Our Ref: EP/58/17/HH

**Town & Country Planning Act 1990 (as amended)
Town & country Planning (Development Management Procedure) (England) Order 2015
Application for Planning Permission for Works or Extension to a Dwelling**

Development Dismantle garden shed and erect 12x8 summerhouse

Location 9 Upper Drive East Preston

Landscape Plan: CLS/418.1D/17

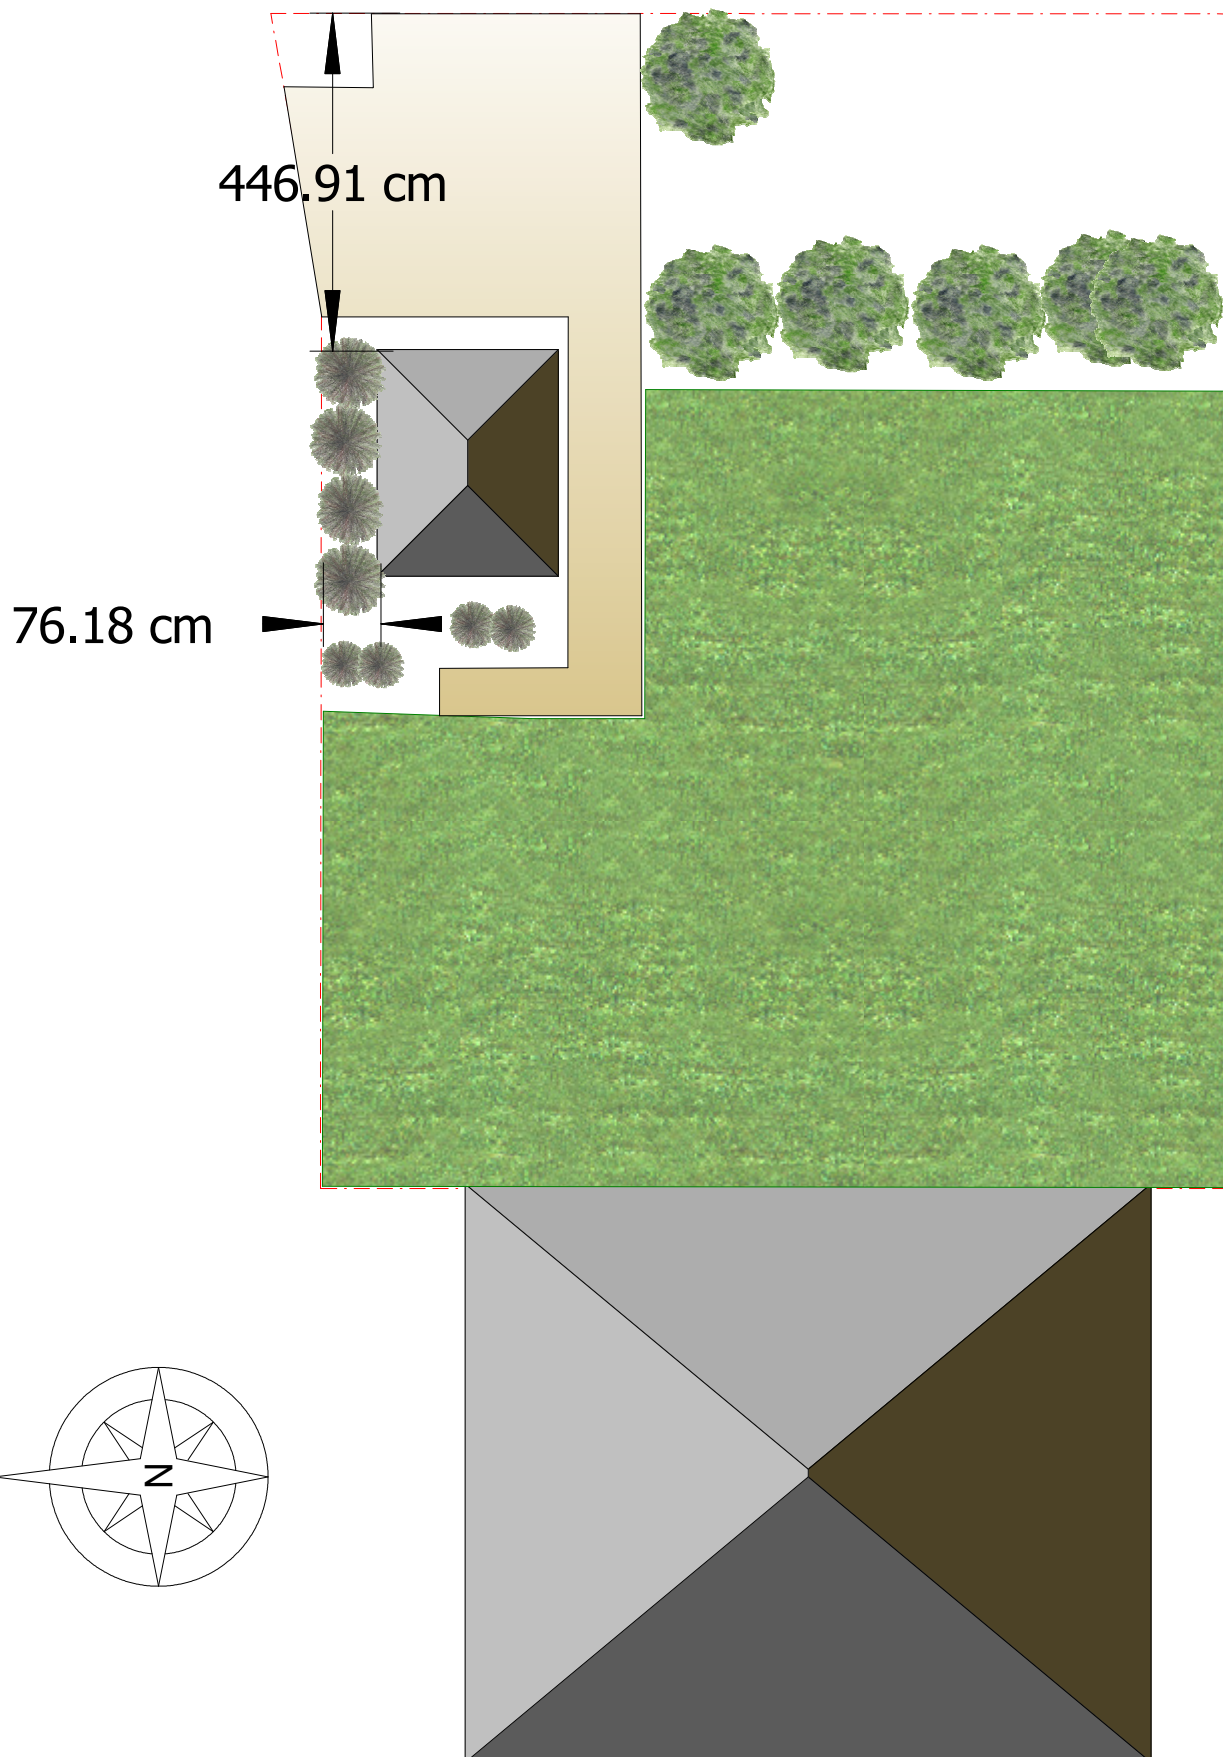
Block Plan

The block plan needs to be drawn to a metric scale such as 1:500 or 1:200. In addition, please annotate the dimensions from the proposal to the boundary lines.

Revision #:	Scale:	Landscape Plan:	Landscape Design by: Steve White
Date: 08/05/2017	1:50	Mrs Leggett Summerhouse	County Landscapes Ltd

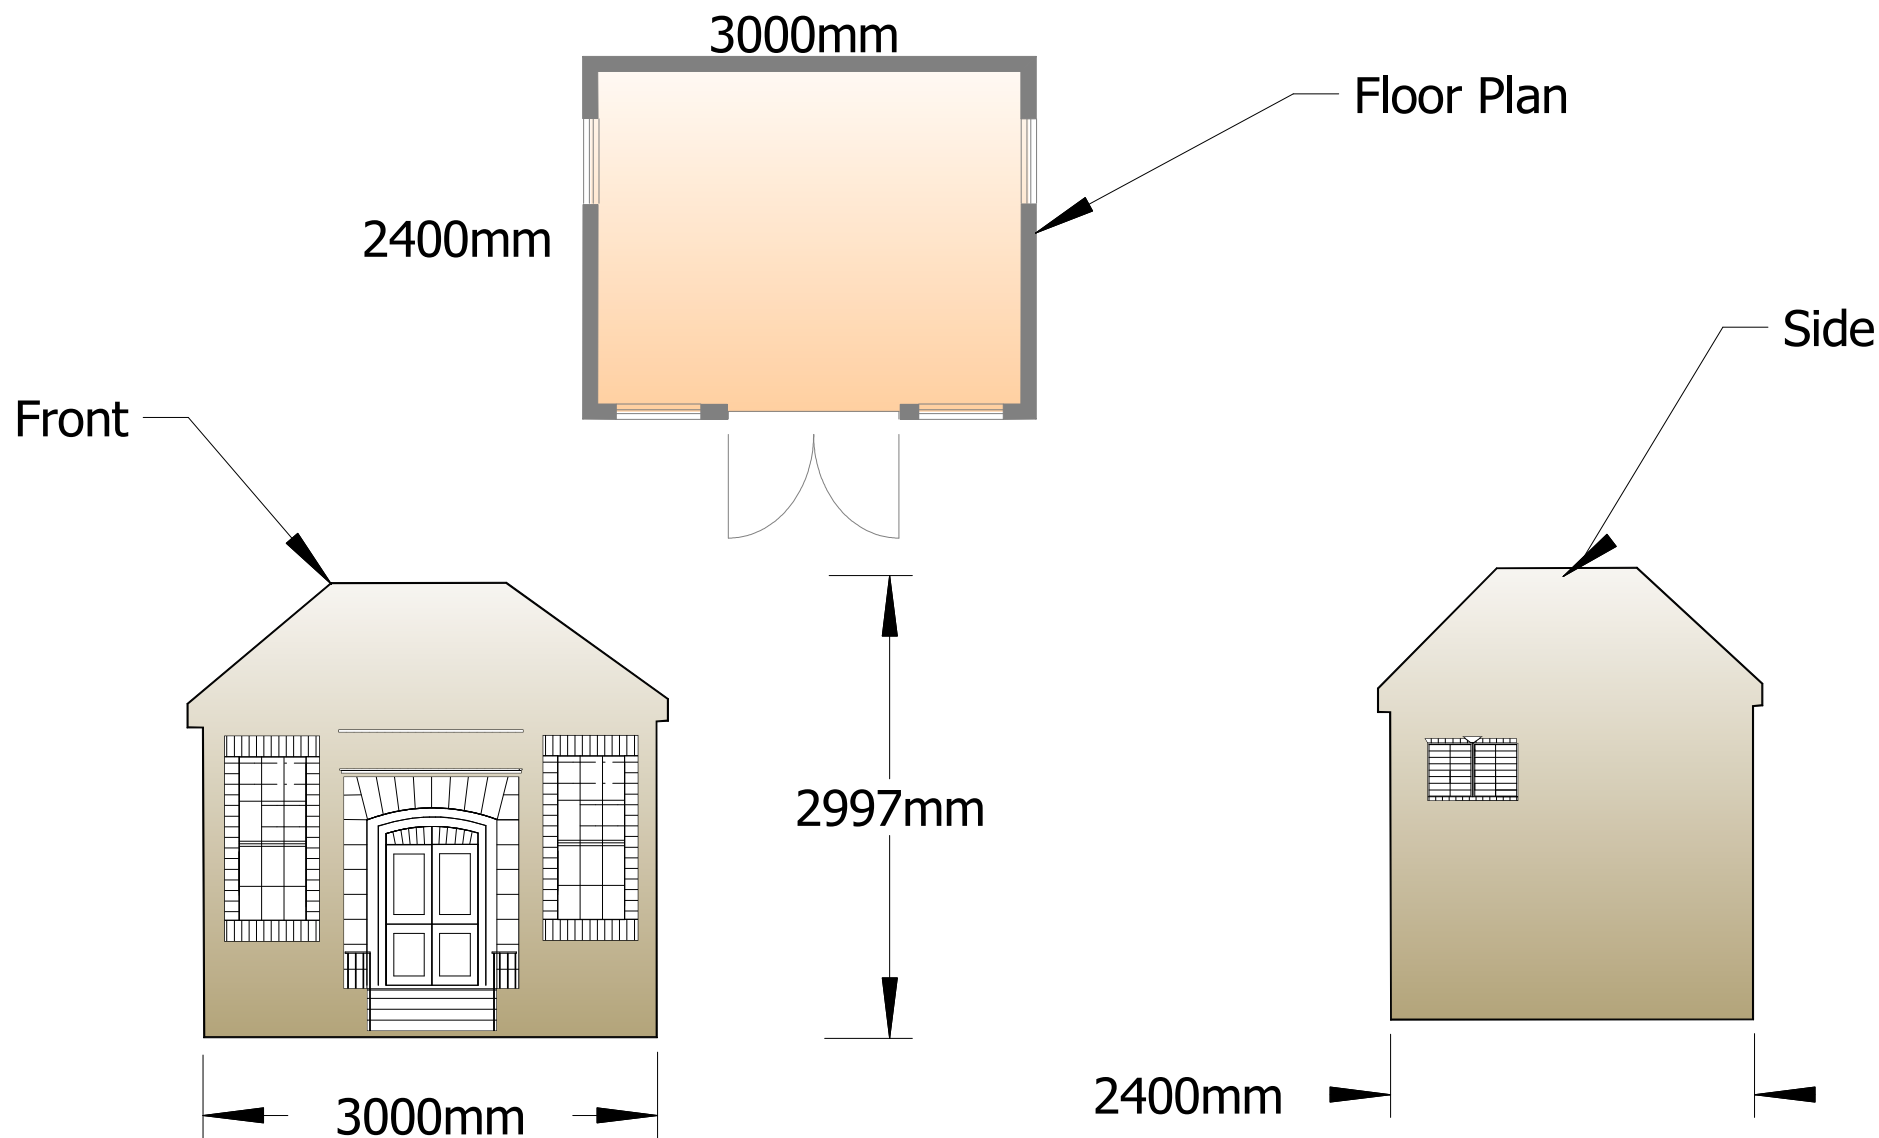
Floor Plans

Please submit 1 electronic or 3 paper copies of clearly labelled proposed floor plans at a scale of 1:50 or 1:100. Further details can be found in the National Validation Requirements.

Elevations

Please submit 1 electronic or 3 paper copies of clearly labelled proposed elevations at a scale of 1:50 or 1:100. Further details can be found in the National Validation Requirements.
